CITY OF PORTLAND BUILDING PERMIT

28 VERMONT AVE

PERMIT ID: 2012-50330

has permission to **New Dormer and repairs**

Plot Plan
28 Vermont Ave.
Portland, Maine

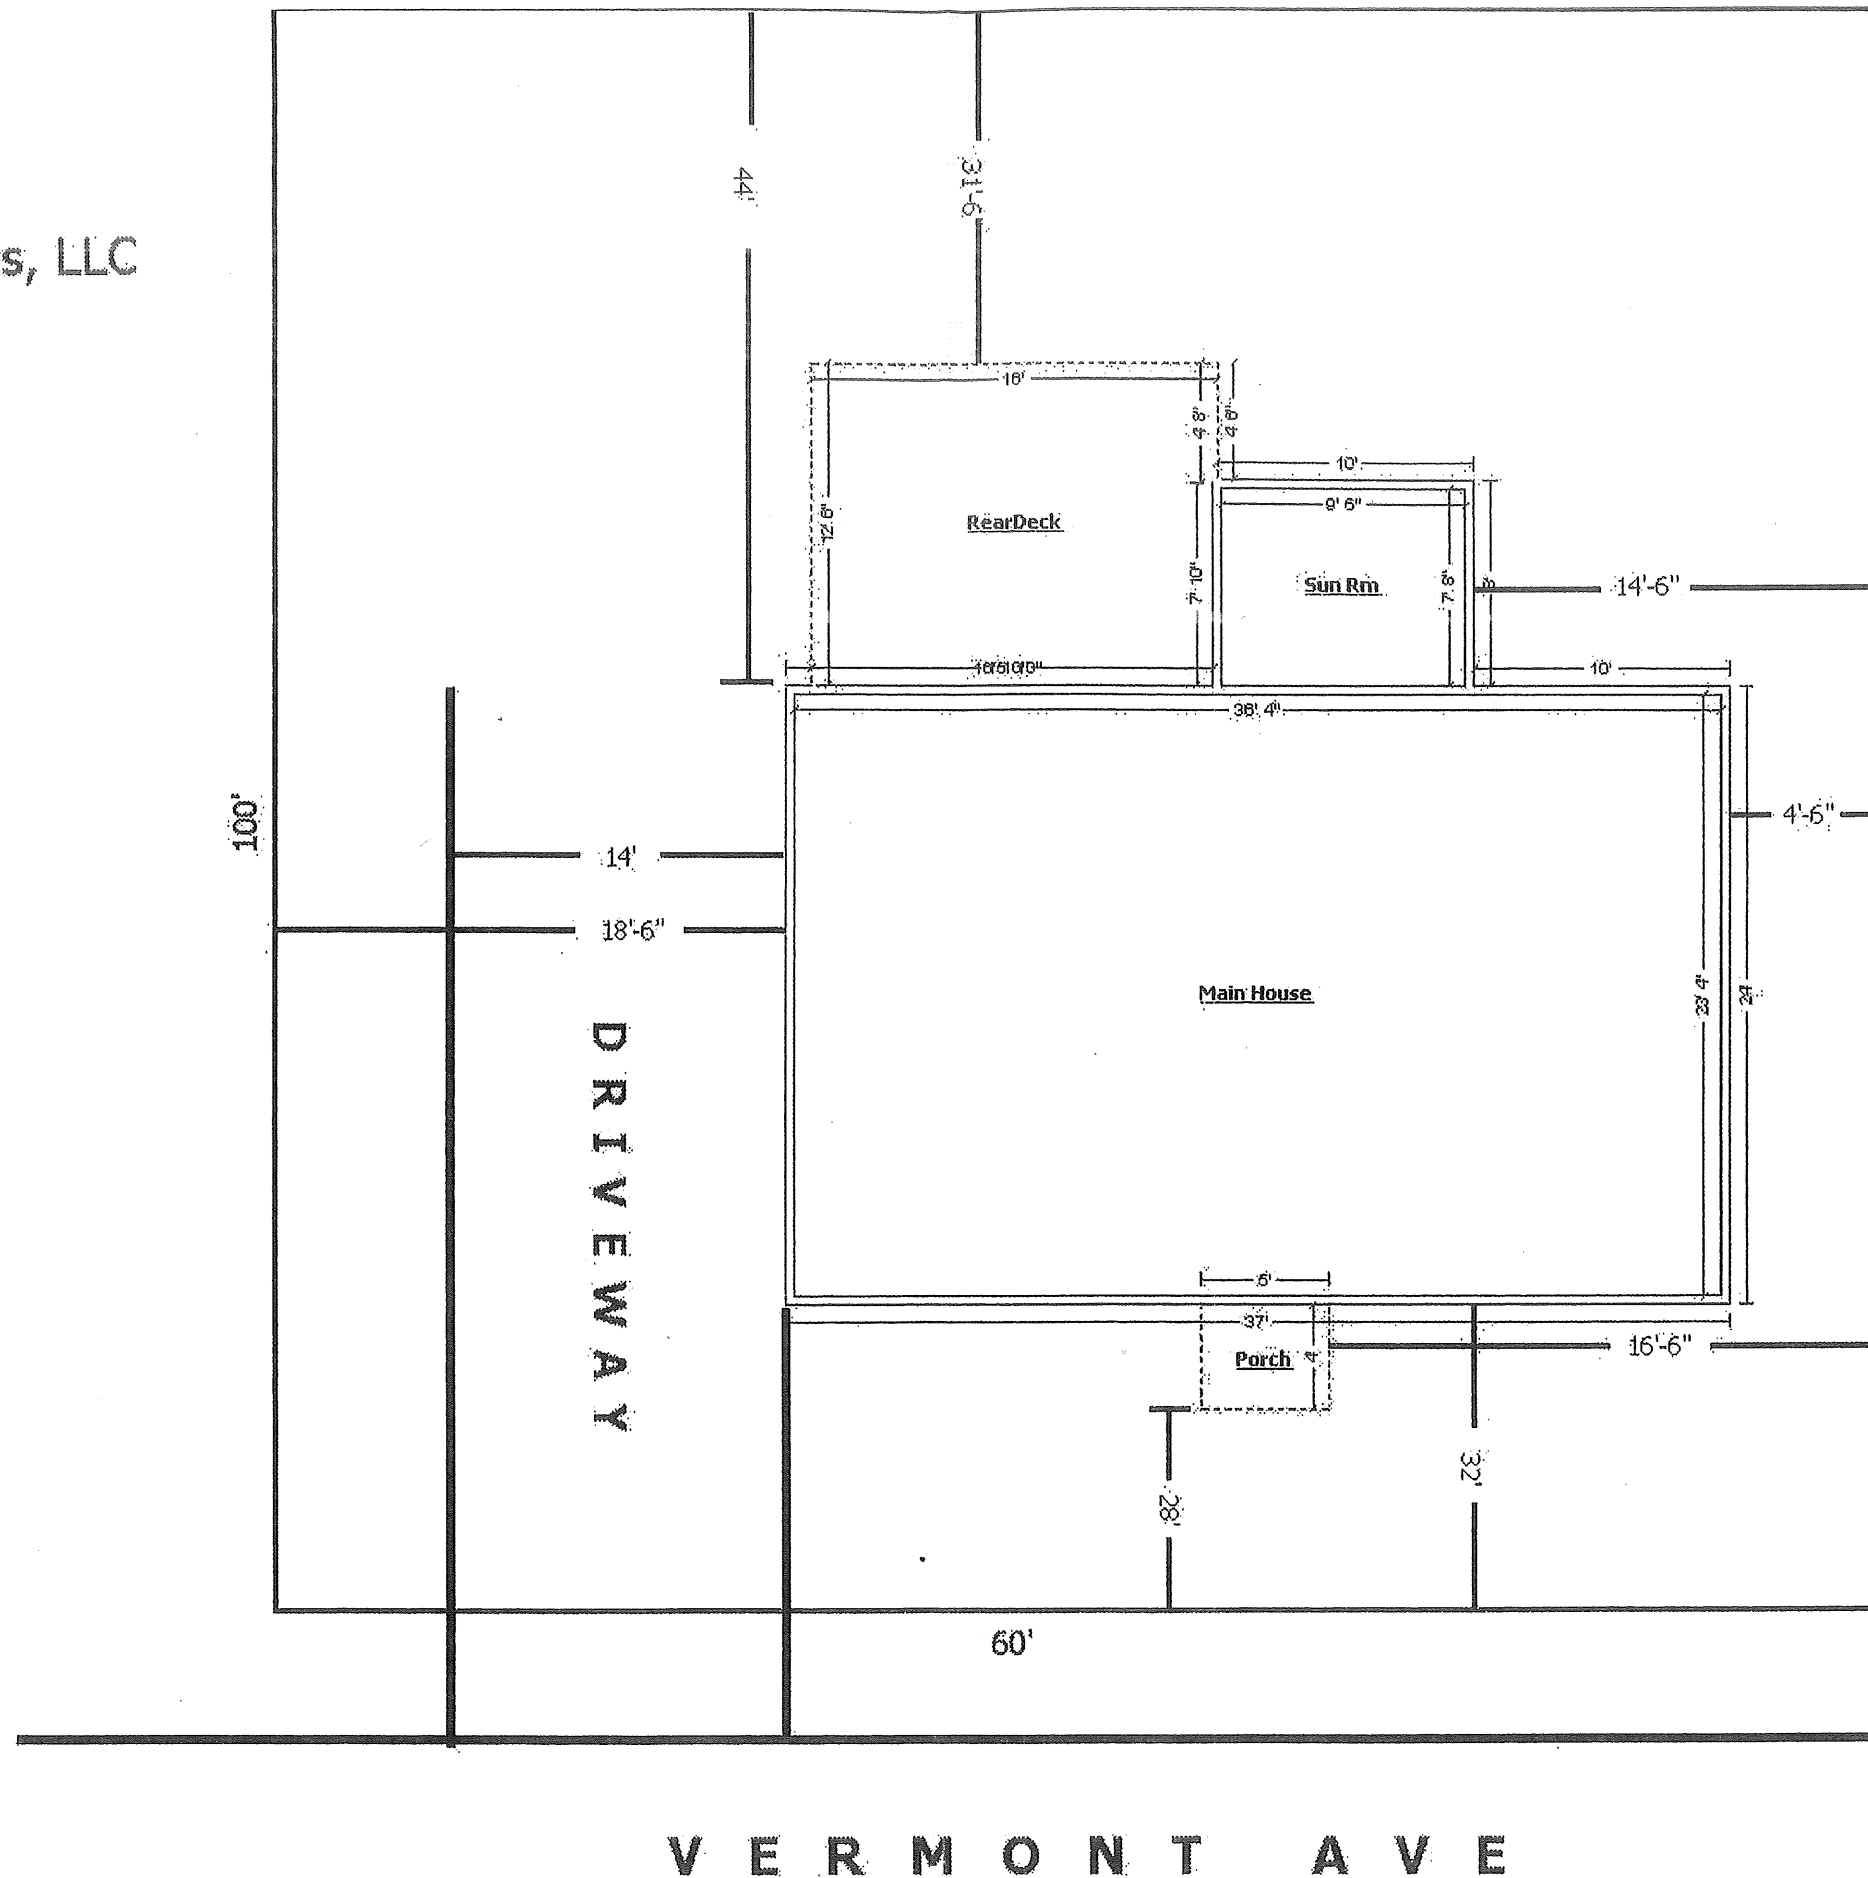
1. This permit is being approved on the basis of plans submitted. Any deviations shall require a separate approval before starting that work.
2. This property shall remain a single family dwelling. Any change of use shall require a separate permit application for review and approval.
3. The existing house does not meet the 8' side setback and the minimum land area per dwelling unit. Using section 14-436(a) the dormer is adding 35 sf. The first floor footprint is 1180 sf. The dormer is a 3% increase in floor area.

NOTE: ROOF PITCH UNDER 3 PITCH.
ROOF RIDGE SUPPORTED.

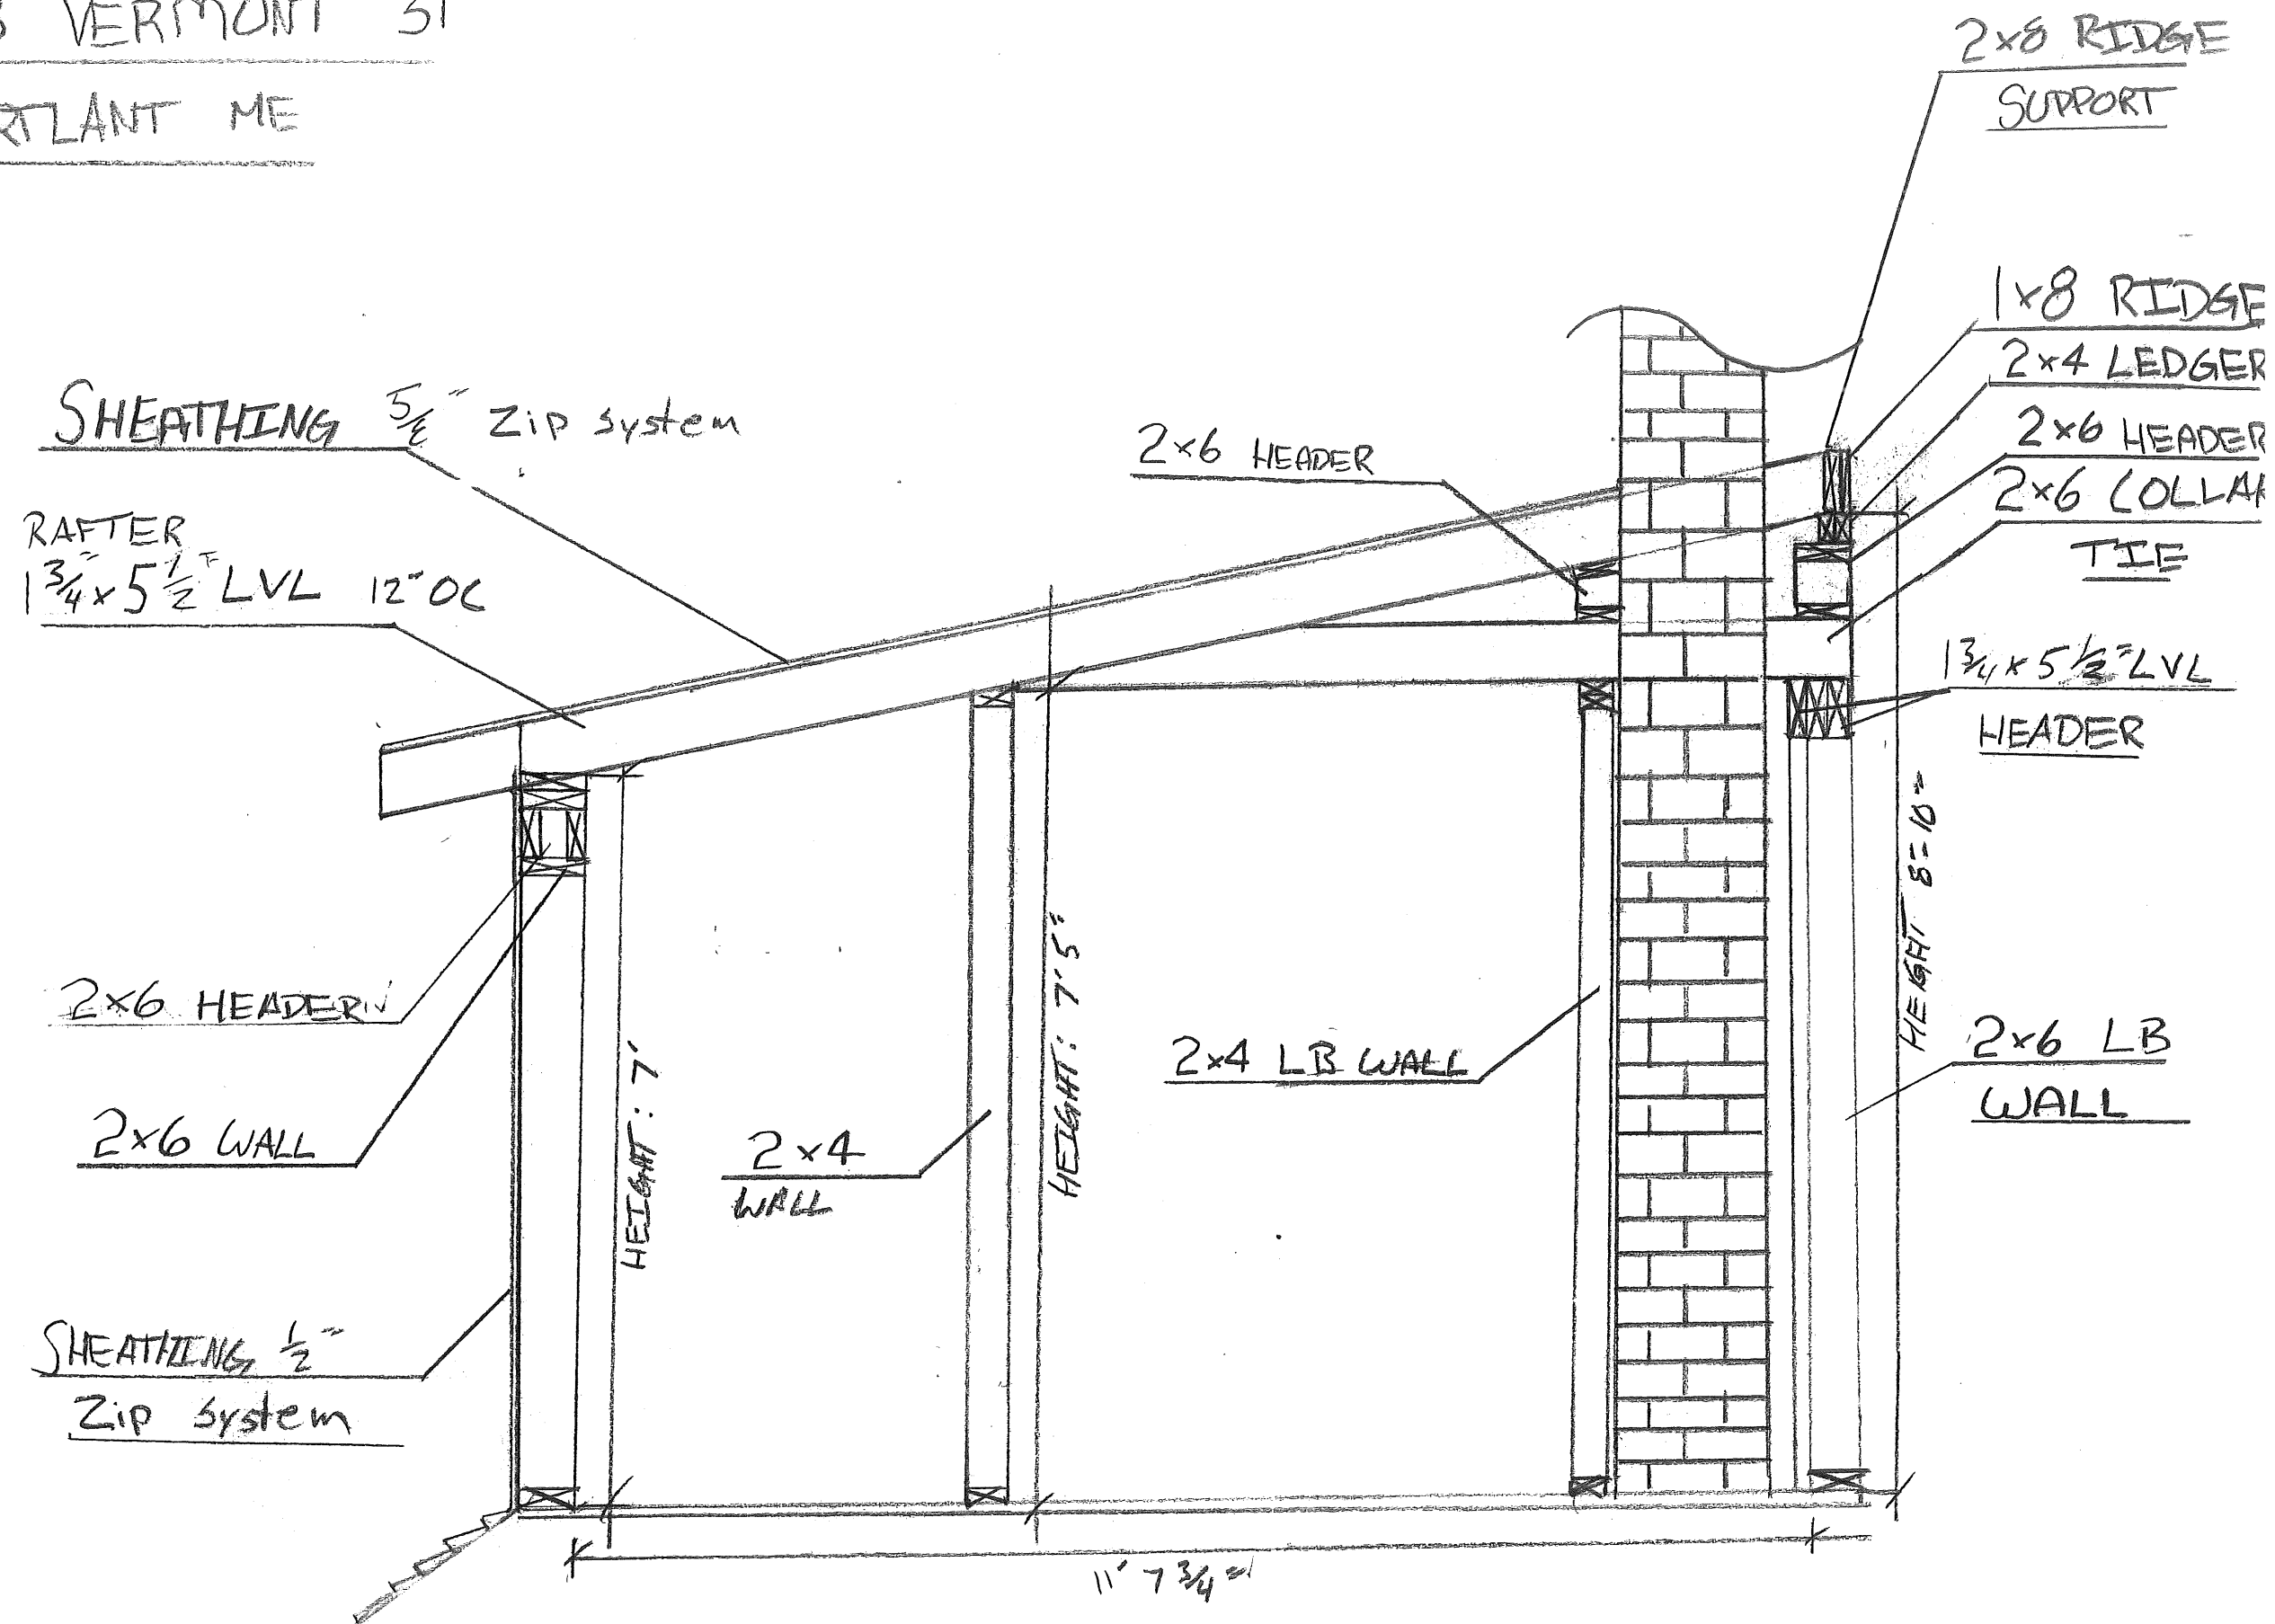
8. Note: Where the roof pitch is less than three units vertical in 12 units horizontal (25-percent slope), structural members that support rafters and ceiling joists, such as ridge

beams, hips and valleys, shall be designed as beams. **Submit specifications for engineered beams to this office prior to construction.**
